Your Ref: OWPC21853
Our Ref: LY/4/19/HH 08-03-2019
Please ask for:
Zac Denton

Proposed first floor side extension, single storey rear extension to existing dwelling and summer house within garden. This application affects the character and appearance of the Lyminster Conservation Area and affects the setting of a Listed Building.

253 Church Lane Lyminster

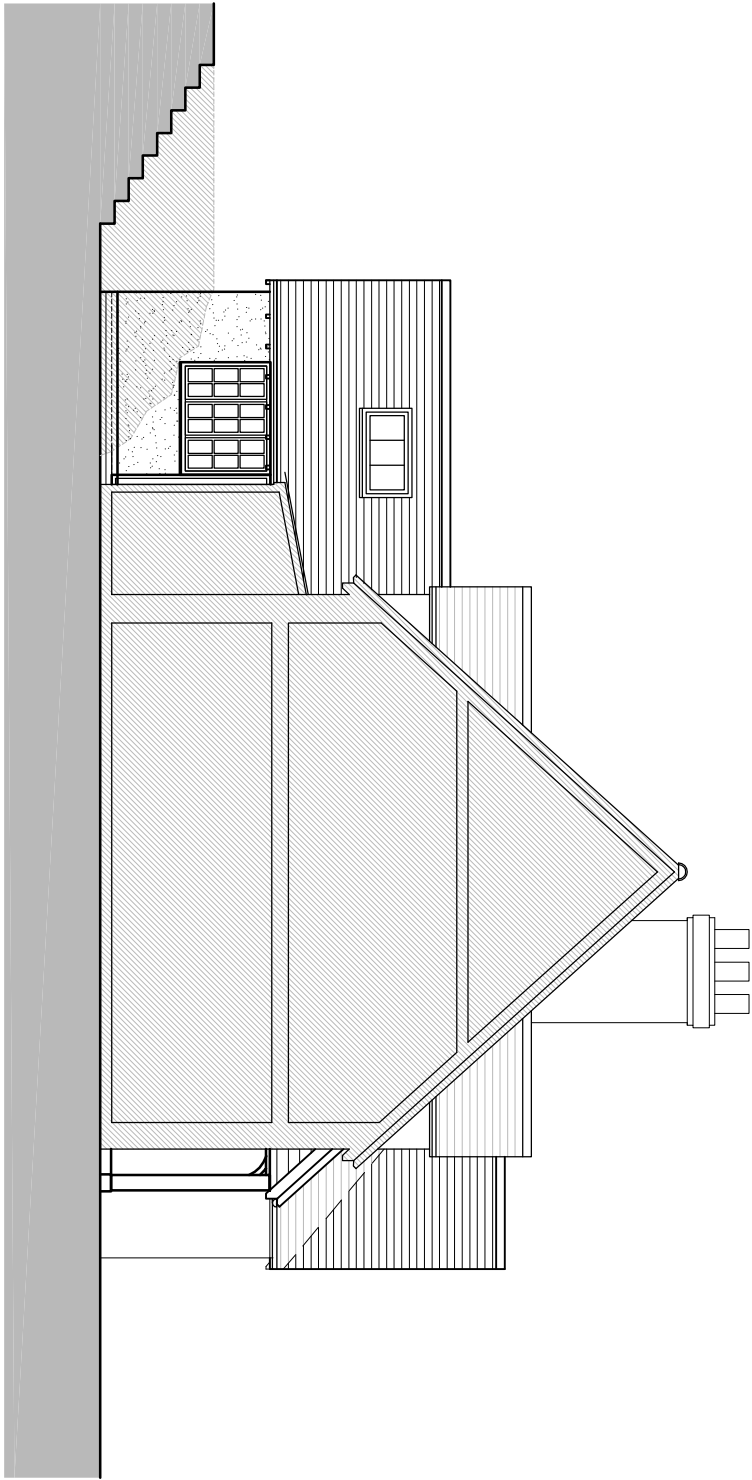
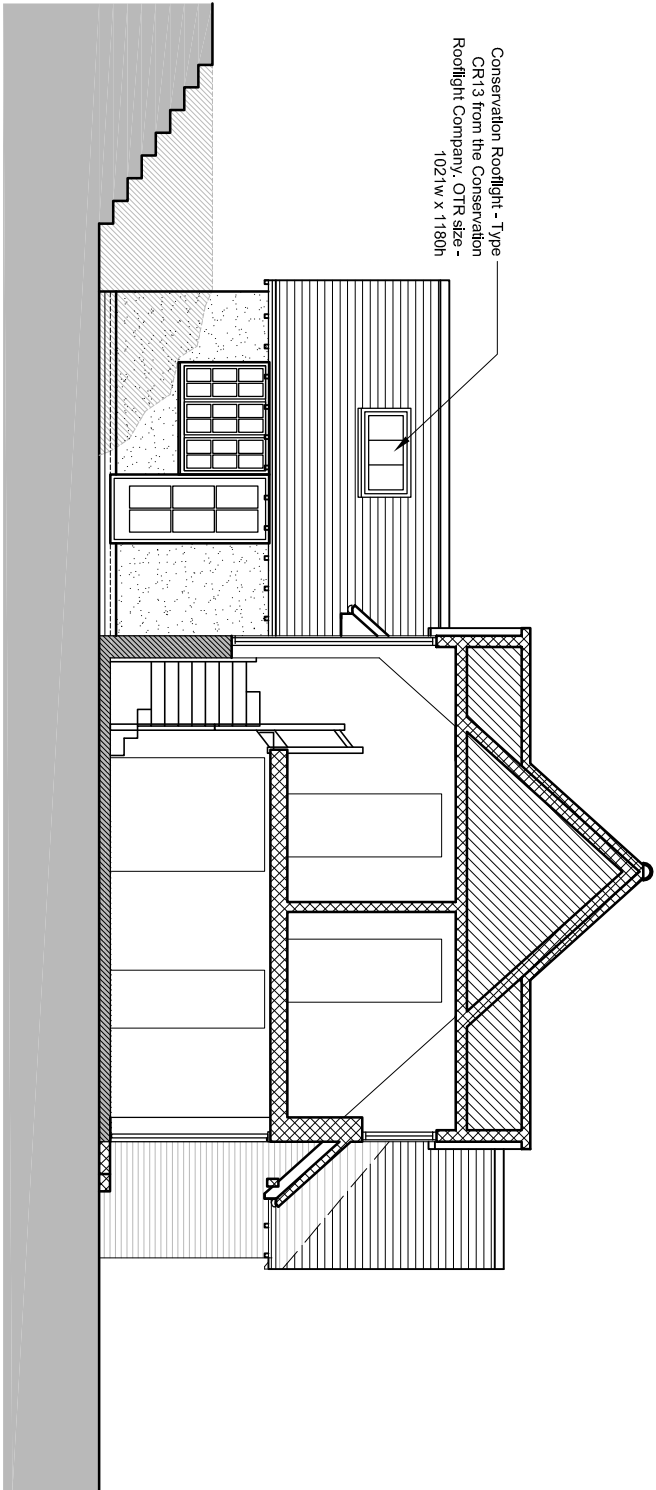
The proposals will dominate the existing cottage and the slightly lower ridge line will not defer this effect. Church Lane is not wide and building an extra storey on the projecting frontage will be the dominant feature when viewed from ground level. The adjacent property no 254, has been granted Planning Consent for a gabled extension only 1.5 m from the boundary, so raising the possibility of the visual gap being infilled by the extensions to no 253 and creating a terrace effect.

Drawing Number: 28_105

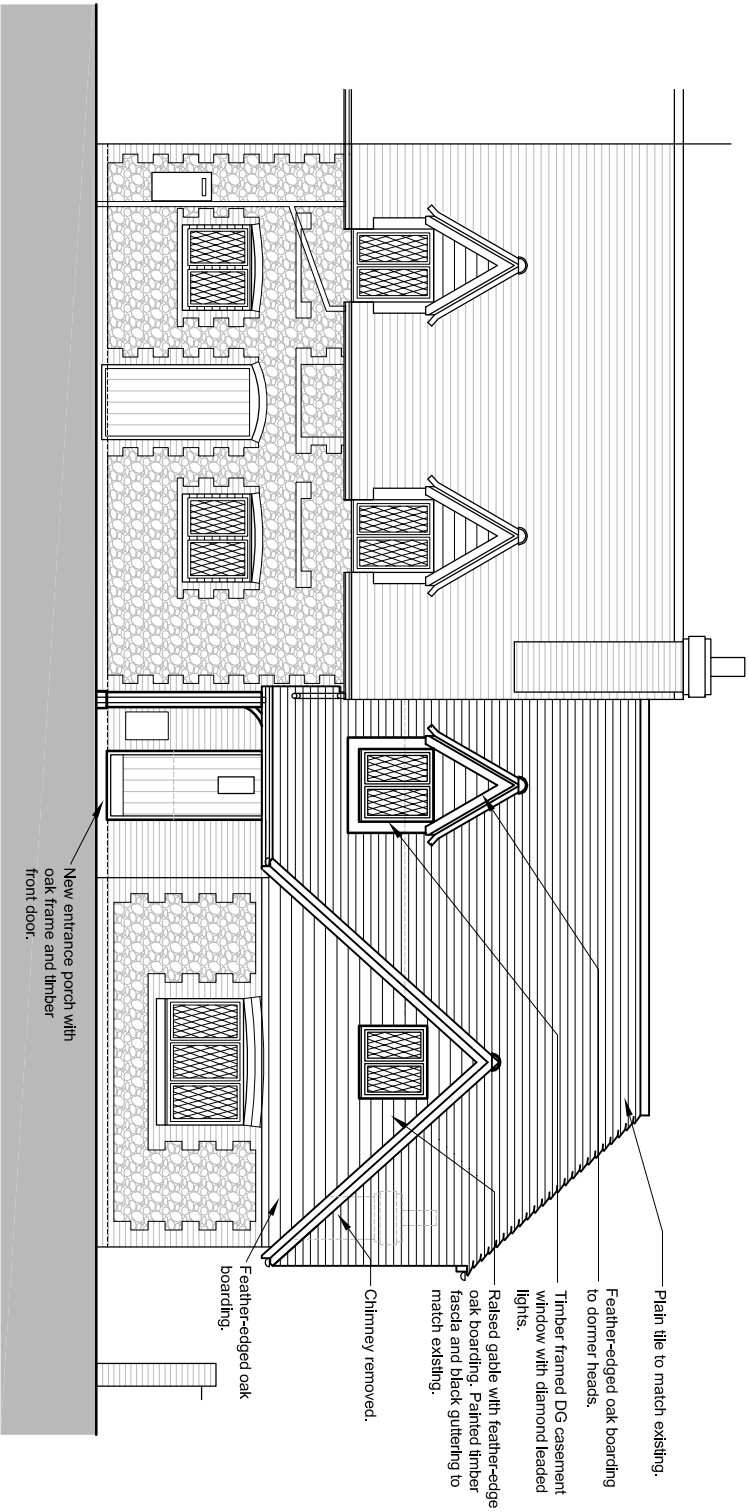
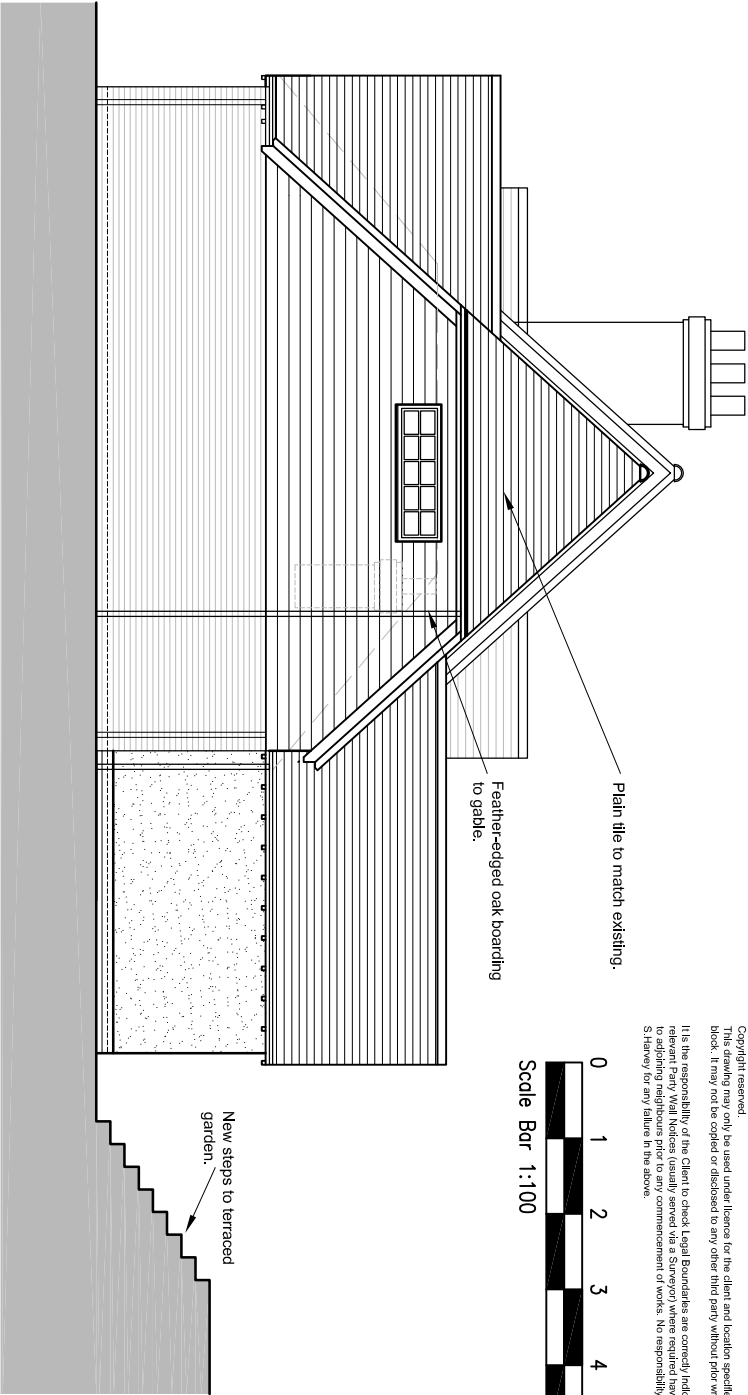
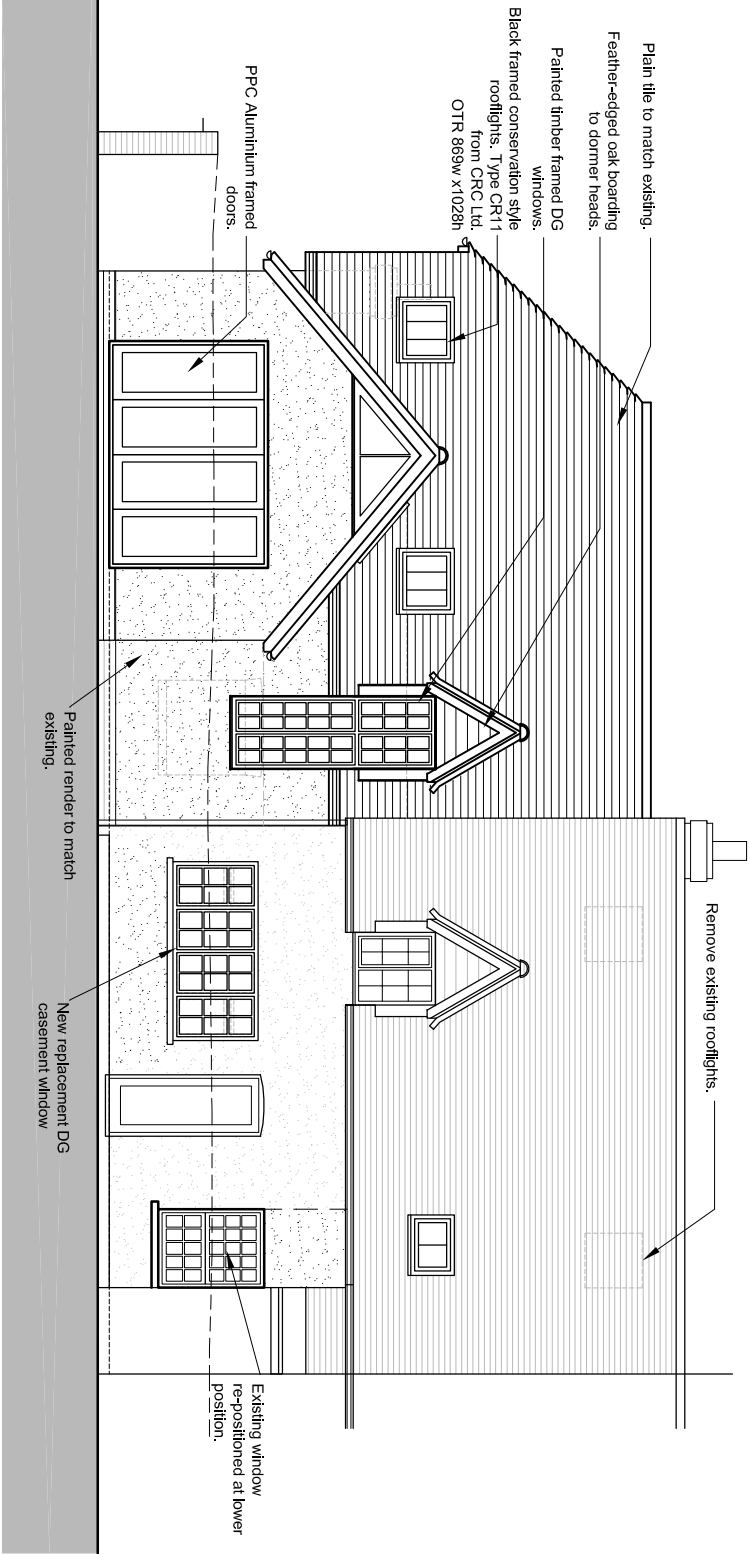
It is unfortunate that no "street scene" drawing has been submitted including this change which would show the potential loss of the gap in this sequence of old cottages.
